FORMAL STRATEGIC OBJECTION: STATE SIGNIFICANT DEVELOPMENT

Development Project: 138 Maroubra Road Mixed-Use Proposal (SSD-81426710)

Objecting Party: Surrounding Locality Residents & Adjoining Neighbours

DRAWN BY	SCALE	SHEET SIZE	PRINT DATE
Author	1 : 500	A1	18/09/2025
DESCRIPTION			5:17:14 PM
SHADOW DIAGRAM PLANS			
SHEET 1			
PROJECT No	DRAWING No	REVISION	
21_435	DA8.300	I

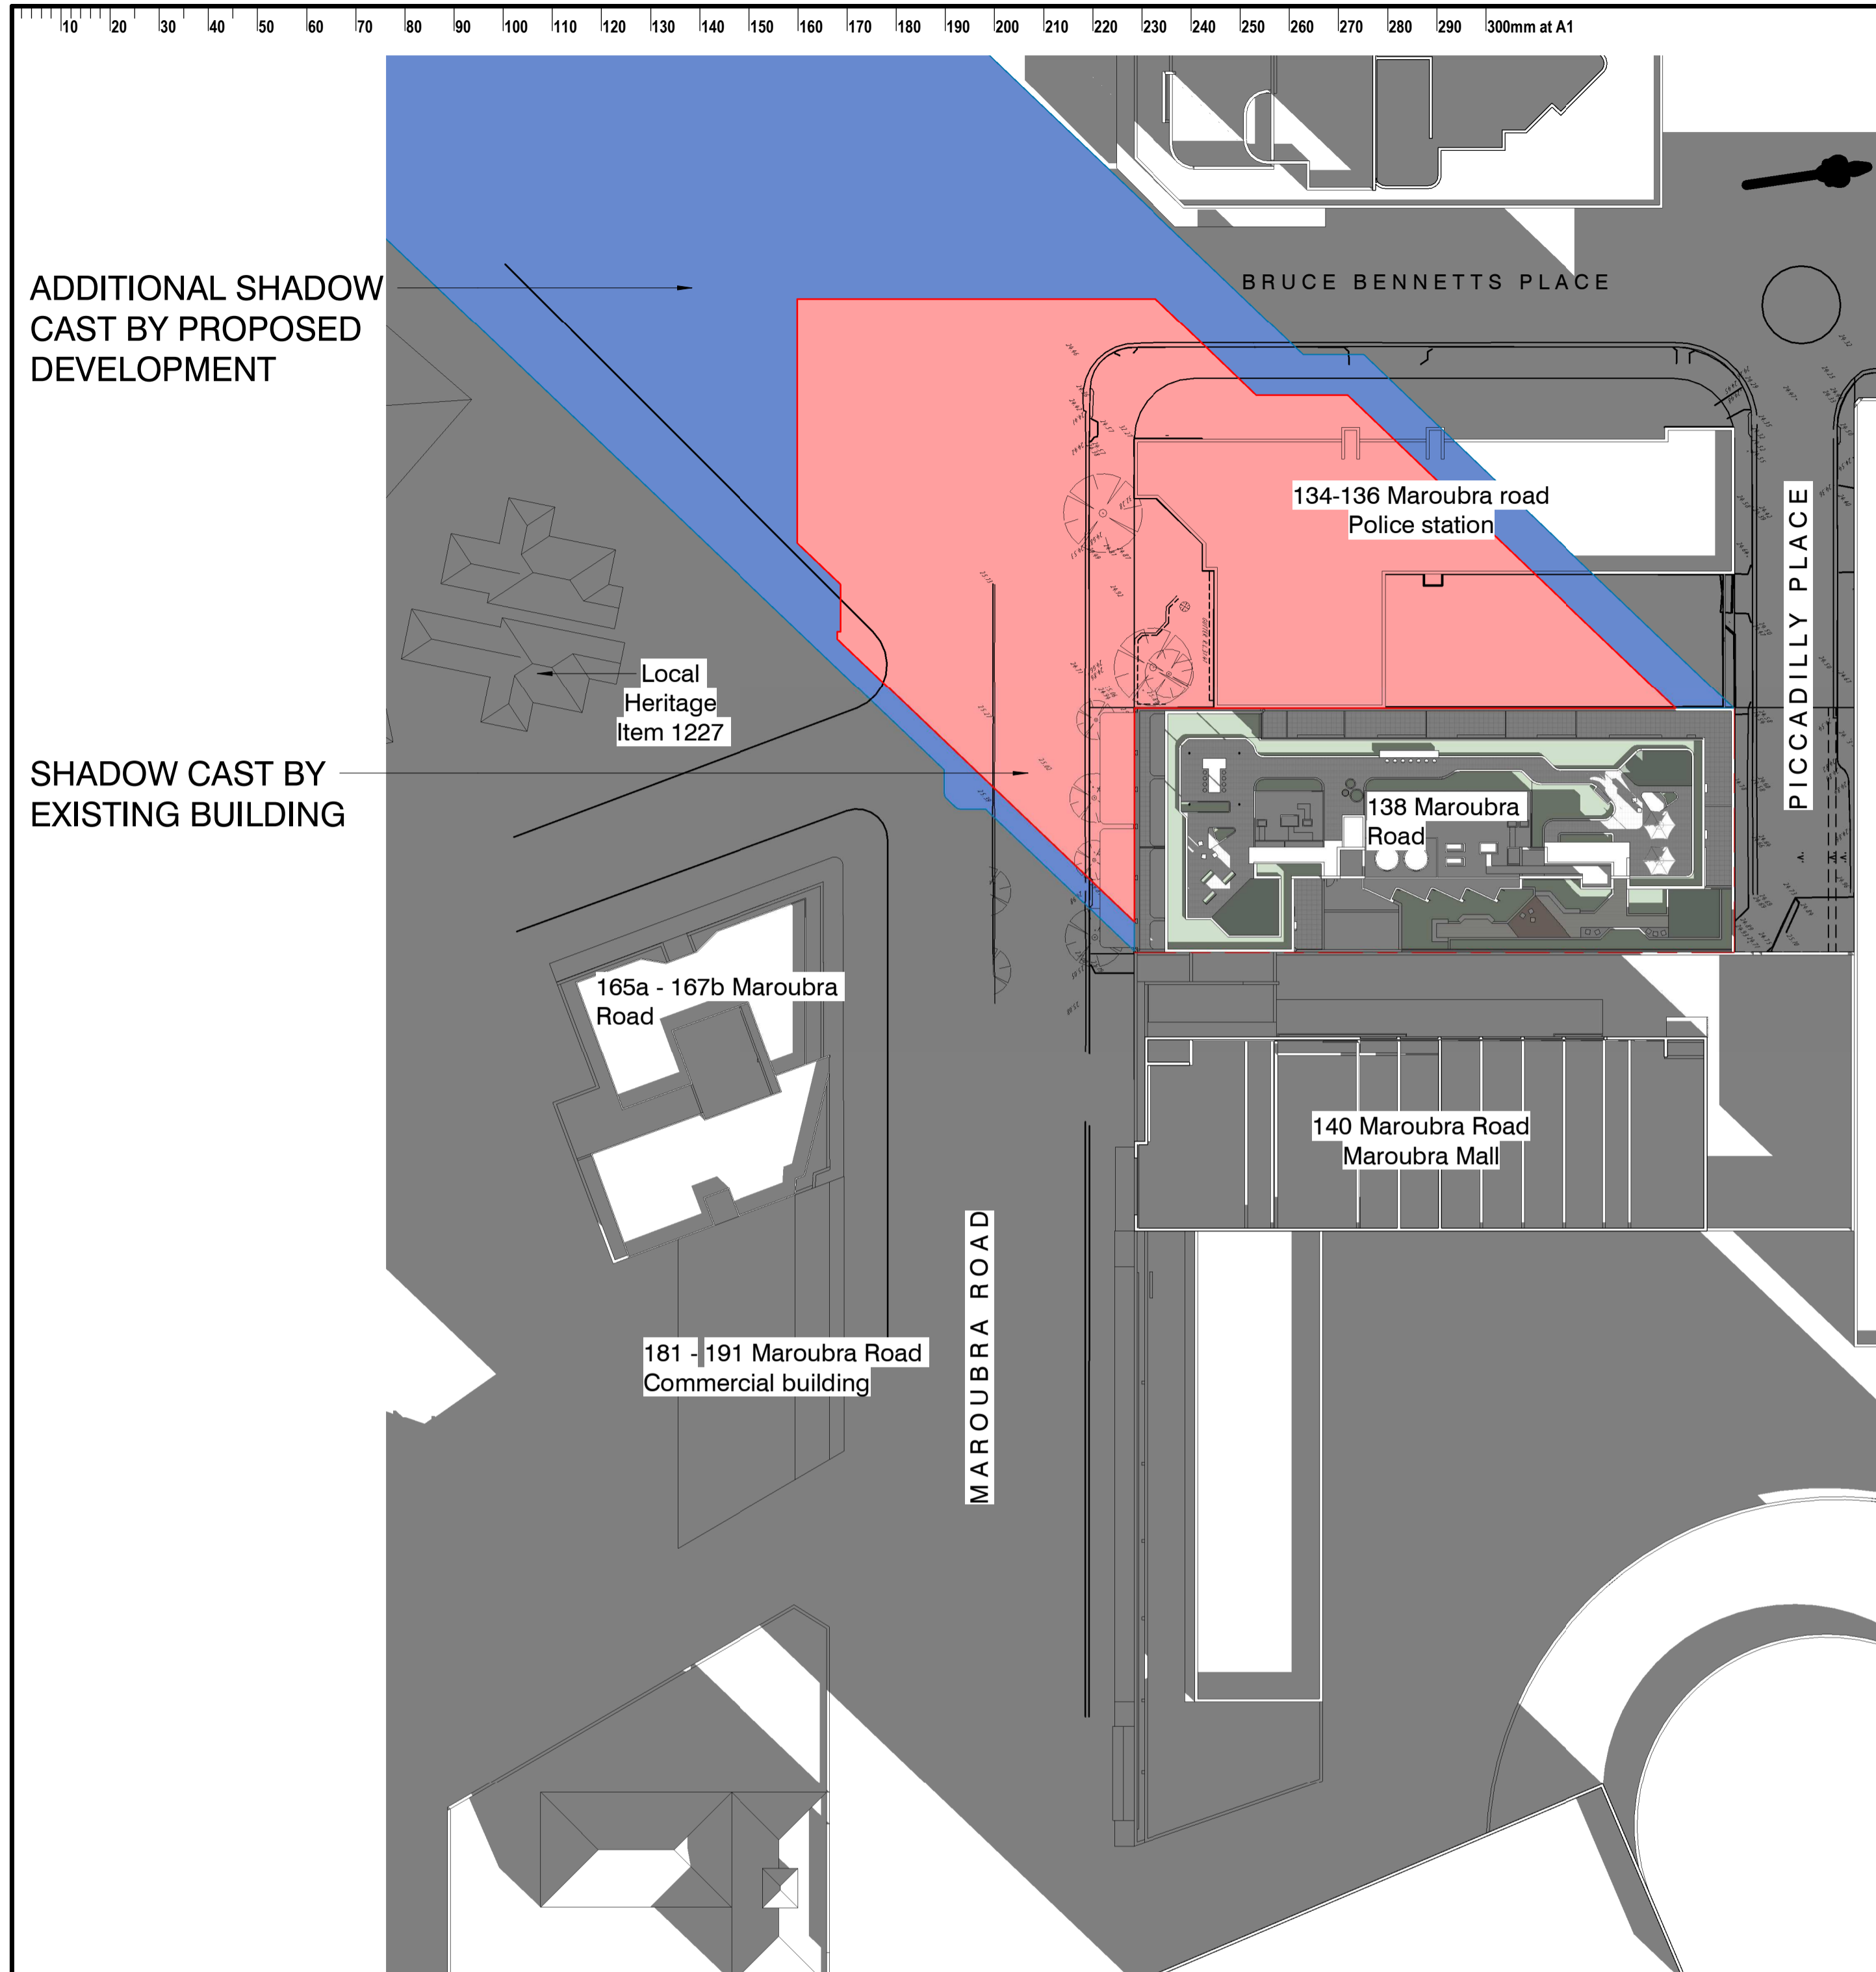
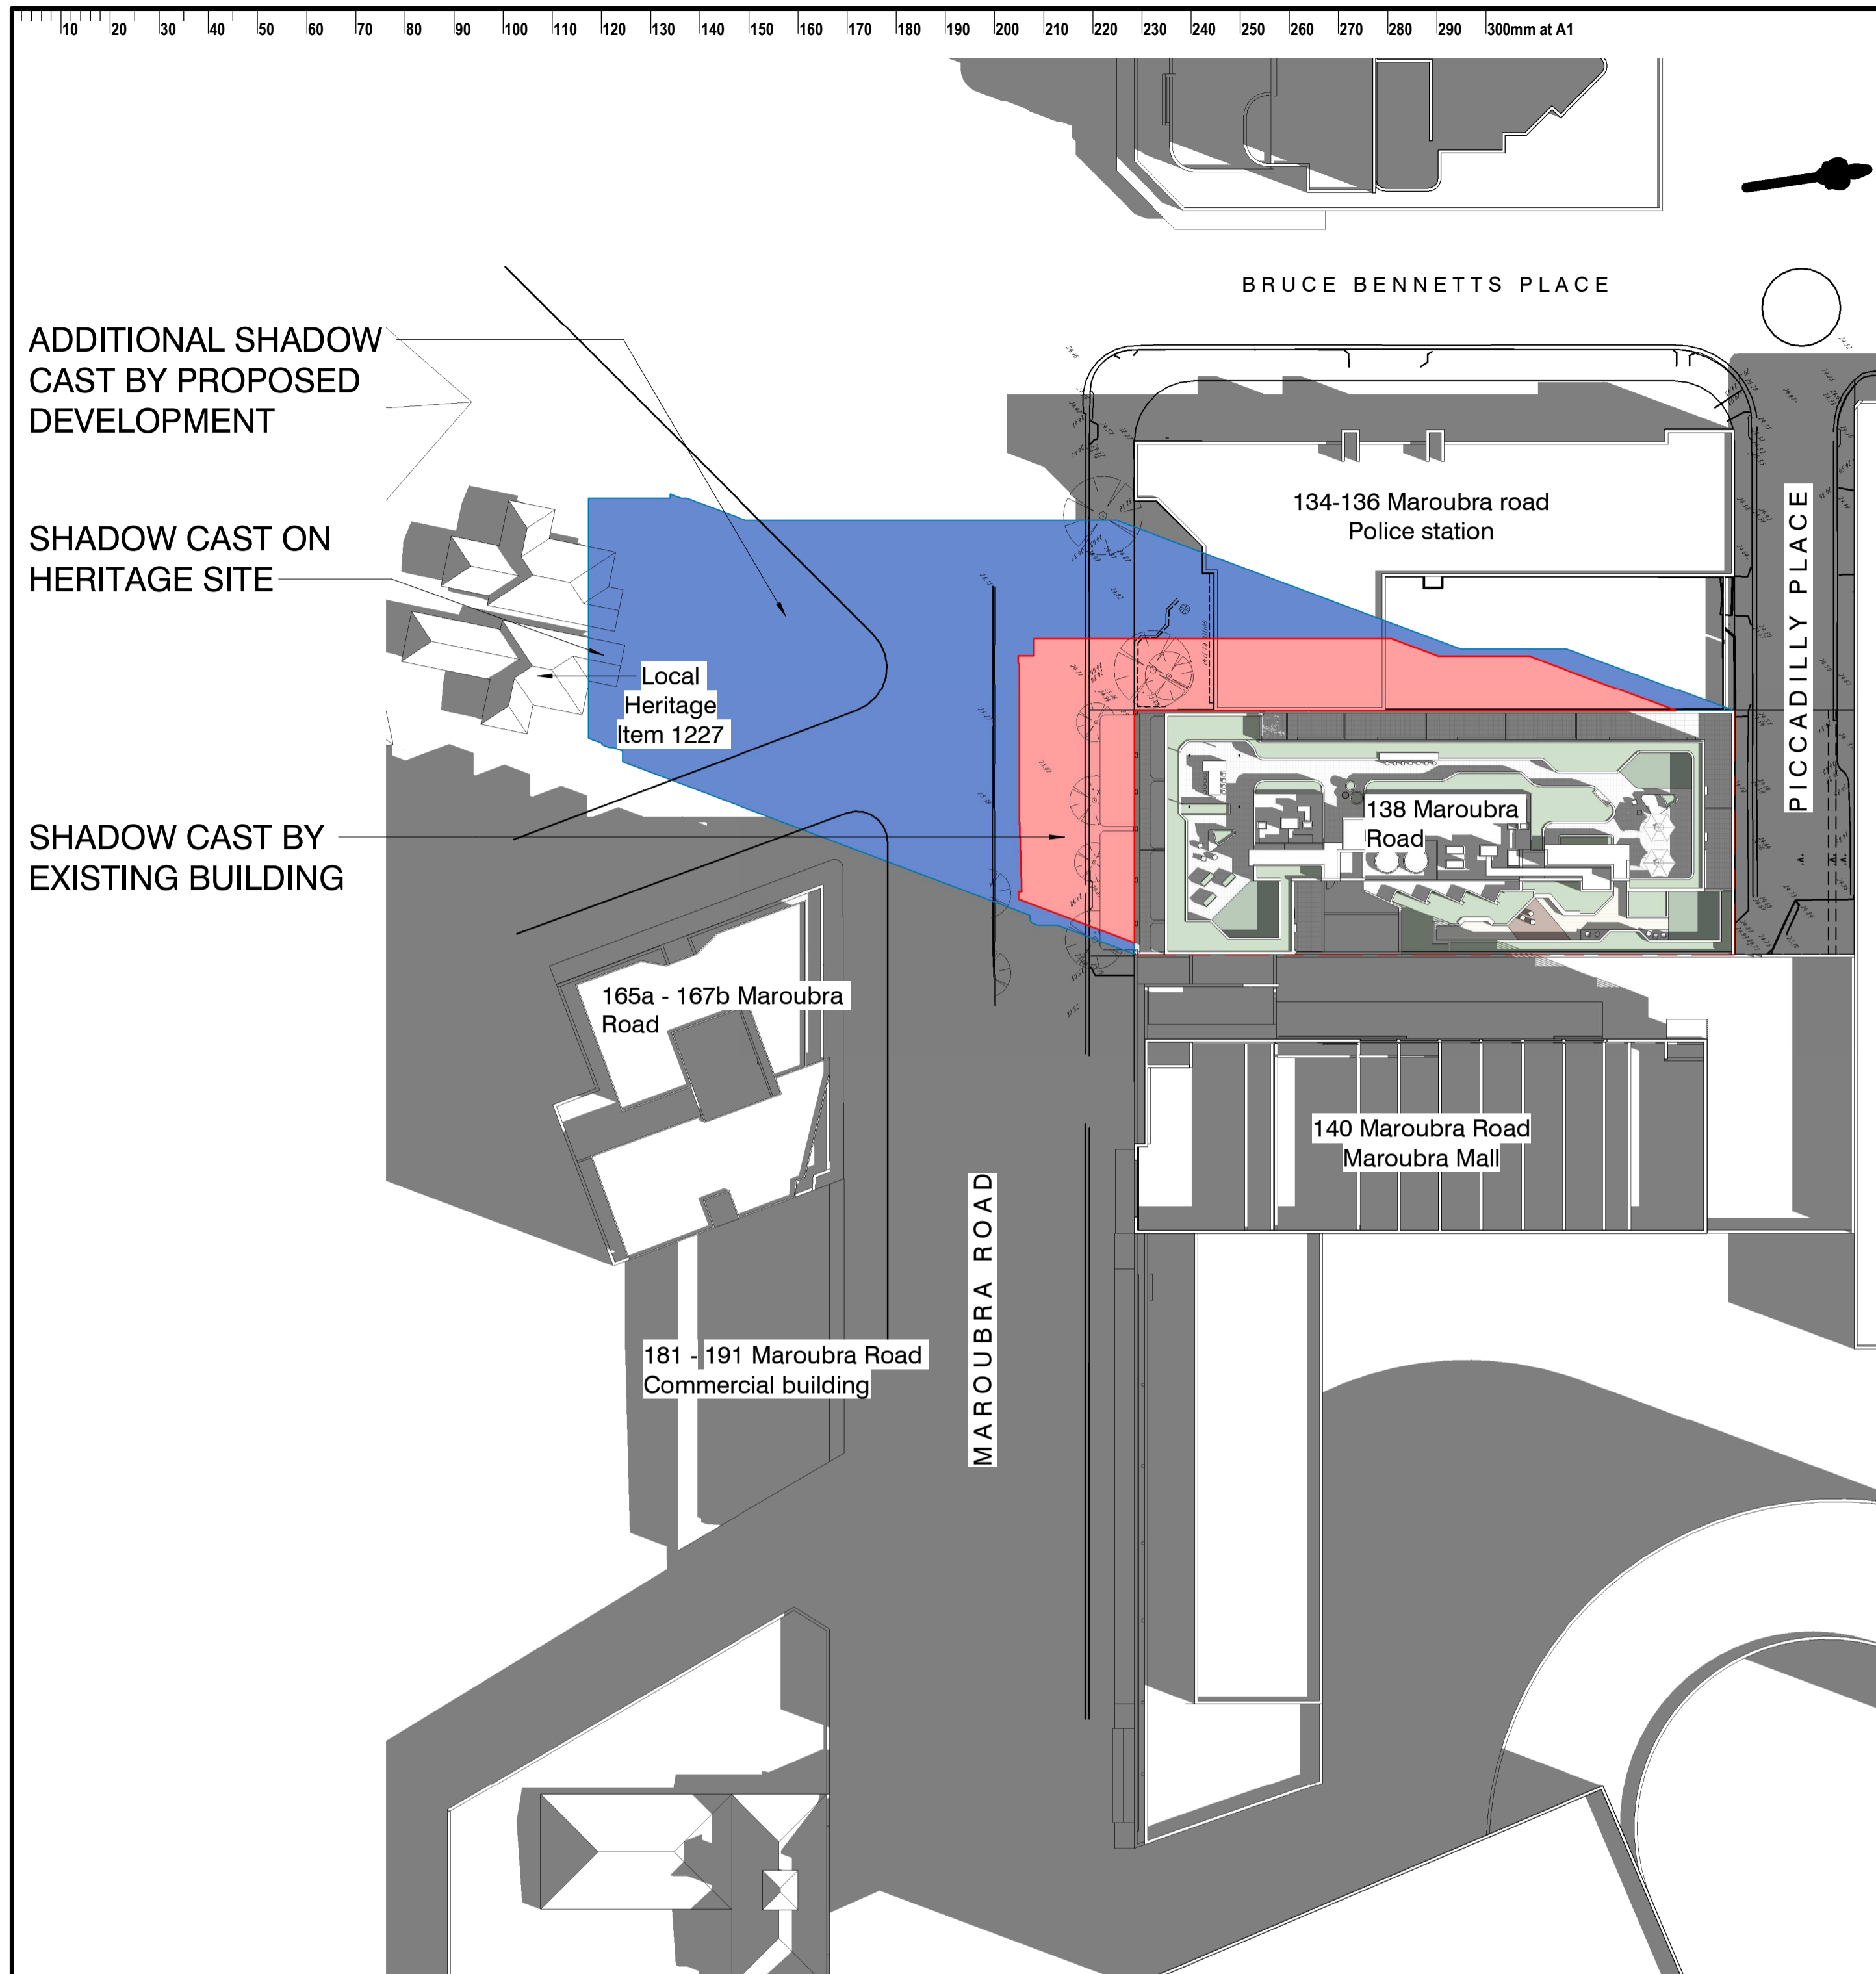
The applicant's submitted shadow modeling relies on broad, regional averages under the Apartment Design Guide (ADG), completely overlooking the localized microclimatic reality of adjoining homes. Building a deep, vertical 10-storey structure directly to the west completely cuts off essential afternoon daylight.

Natural sunlight is a basic requirement for health, physical comfort, and natural apartment temperature control. Stripping adjacent homes of afternoon light hours degrades the baseline well-being of the surrounding community. This loss is felt most acutely by our less-mobile senior residents who stay indoors and rely heavily on natural sunlight for physical health and daily internal warmth.
